**Our Case Number:** ABP-319306-24

**Re:** Proposed development of Cavan Town Sports Campus  
in the townlands of Kilnavara, Lurganboy (Loughtee Upper By), Creighan and Rosscolgan in Cavan  
Town.

**R.E. Application to An Bord Pleanála for approval under Sections 175 and 177AE of the Planning and Development Act 2000 (as amended) and the Planning and Development Regulations 2001 (as amended) by Cavan County Council for Cavan Regional Sports Campus**

Drawing No:			Status
CSC-MCA-XX-XX-DR-A-2005			Rev. P01
All dimensions are in millimetres. Figured dimensions to be taken in preference to scale dimensions. Dimensions to be checked onsite. © 2020 McAdam Design Ltd.			
Plot Date: 08/03/2024 11:02:33

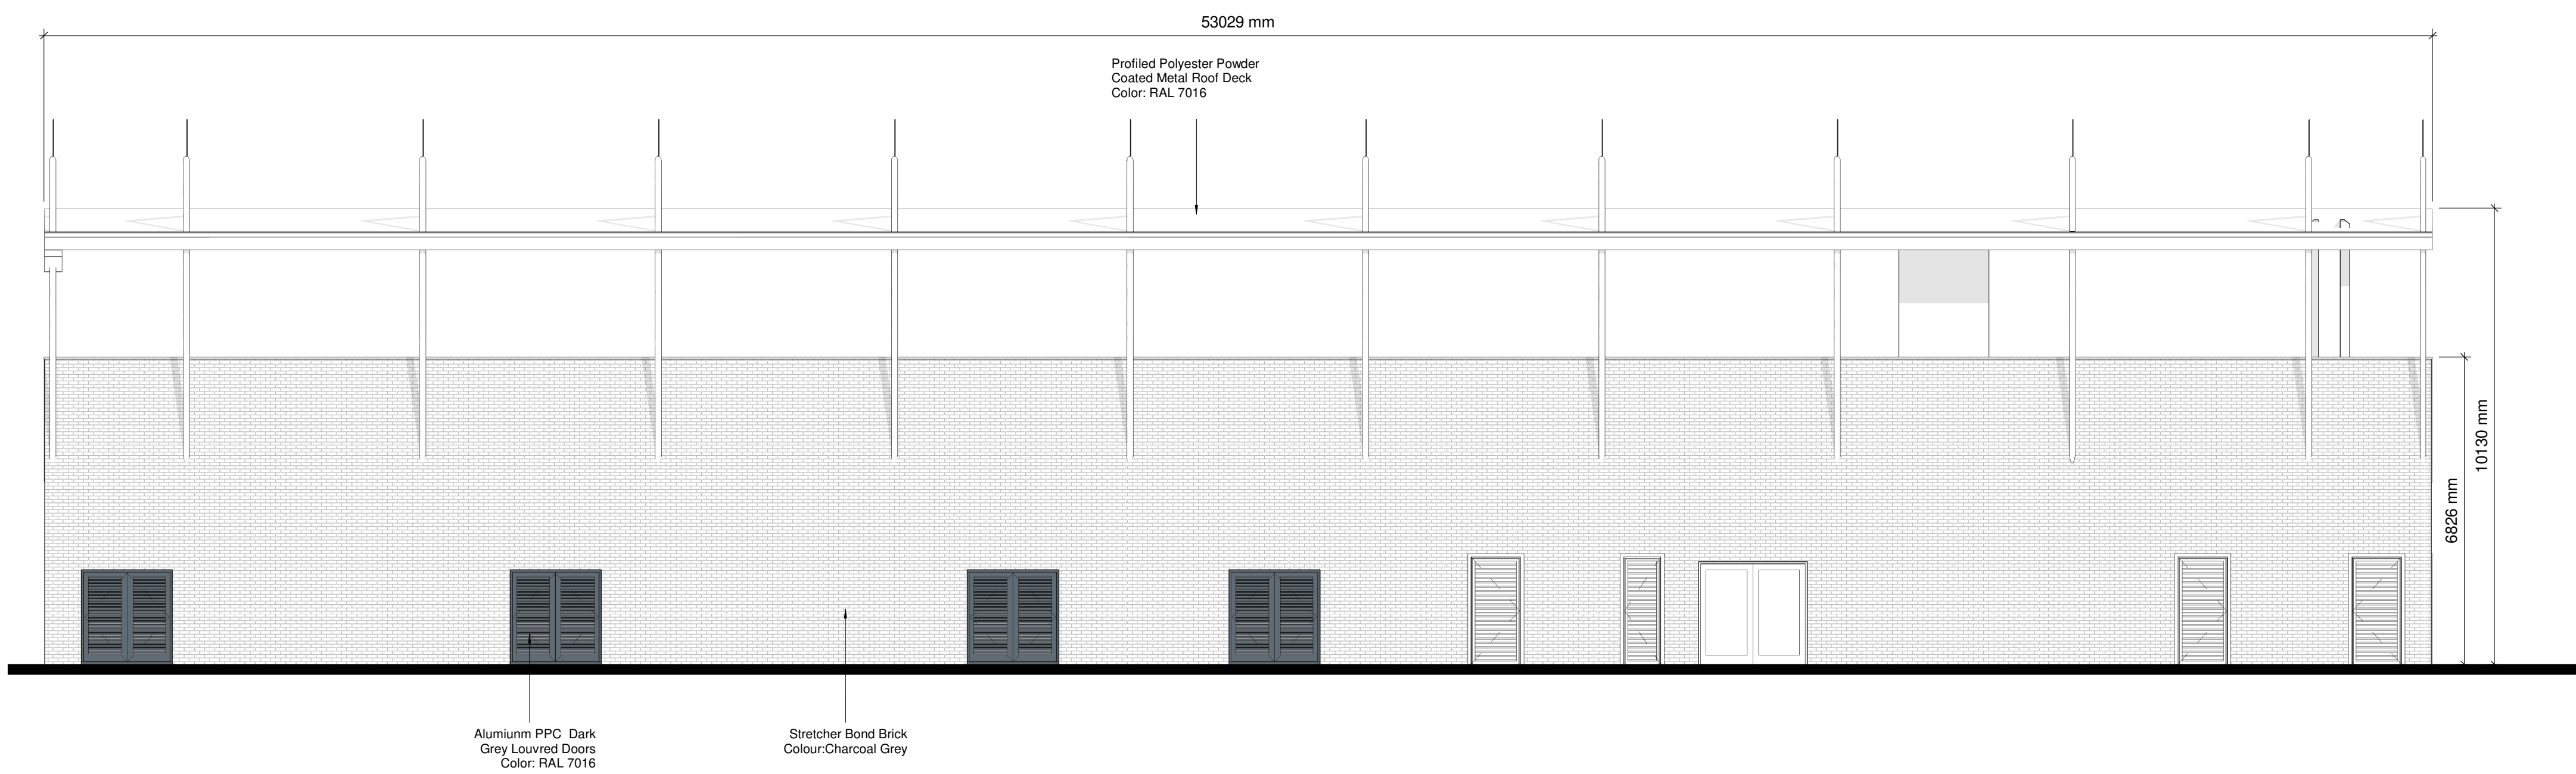
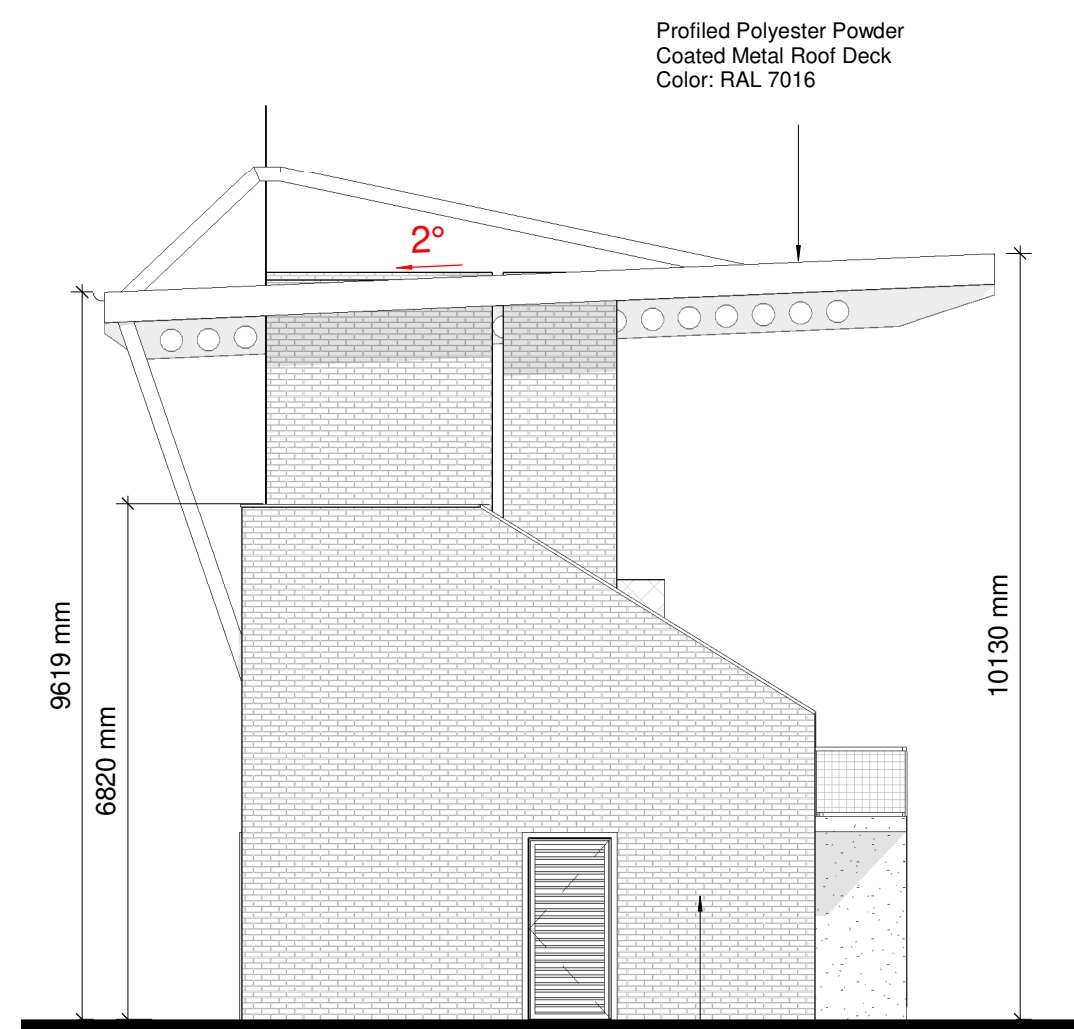
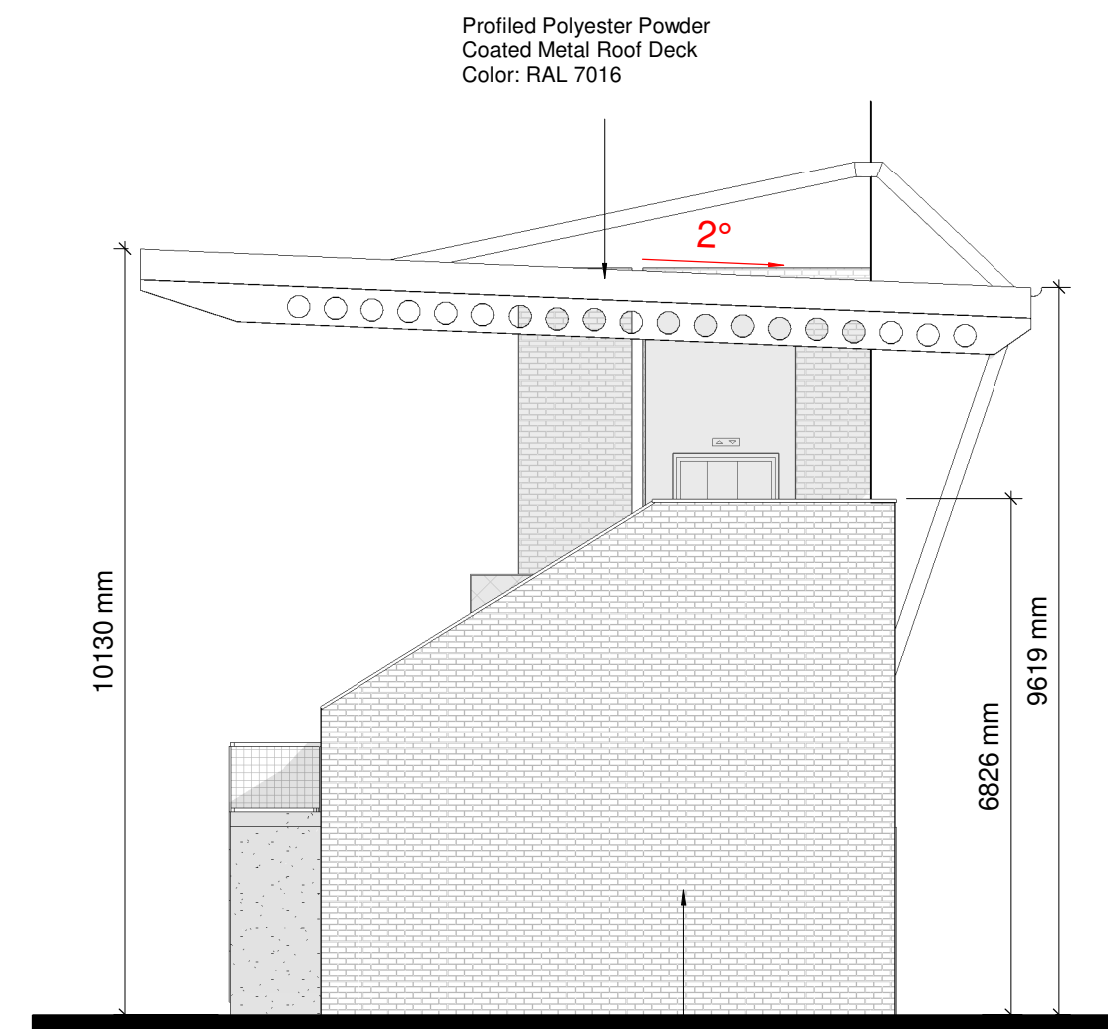
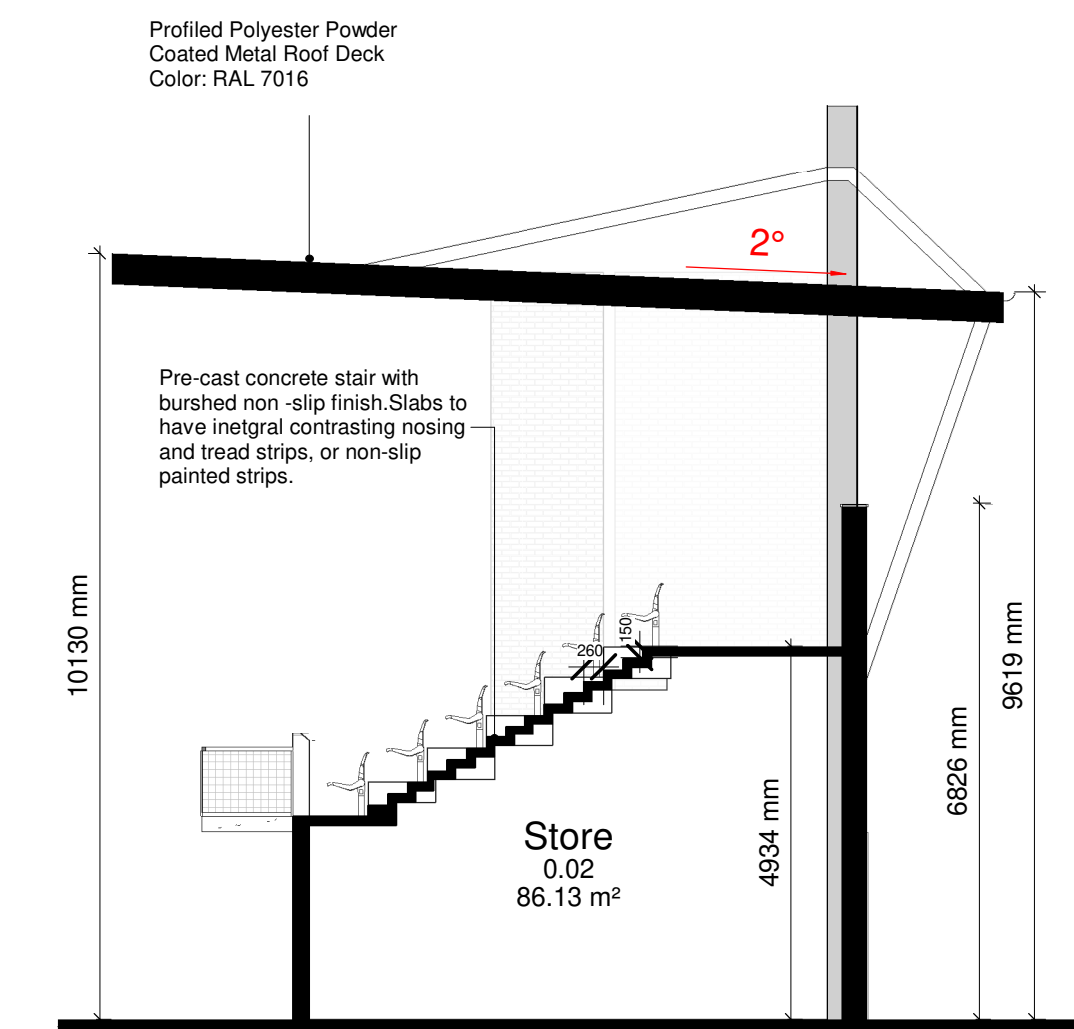
It is not possible to assess the visual impact of the development as the drawings are not consistent with each other. The general layout drawing, A2156-100-11, shows the location of section line 1B, extending through a number of properties to the north. The section line is facing Kilnavaragh lane. Drawing CRSP-MCA-00-00-DR-C-1800-P1 shows earthworks cut and fill levels, moving from cut to fill north to south across the location of section line 1B. The sections provided however are not along section 1B as it does not correlate with the earthwork cut and fill levels, does not show any boundary walls, does not show fence lines, pathways, pitch boundaries, floodlight towers etc. It is also questioned what building is shown on 1B of csc-mca-xx-zz-dr-a-4101, as the elevation and scale of the spectator stand does not match that of csc-mca-xx-xx-dr-A-2005.
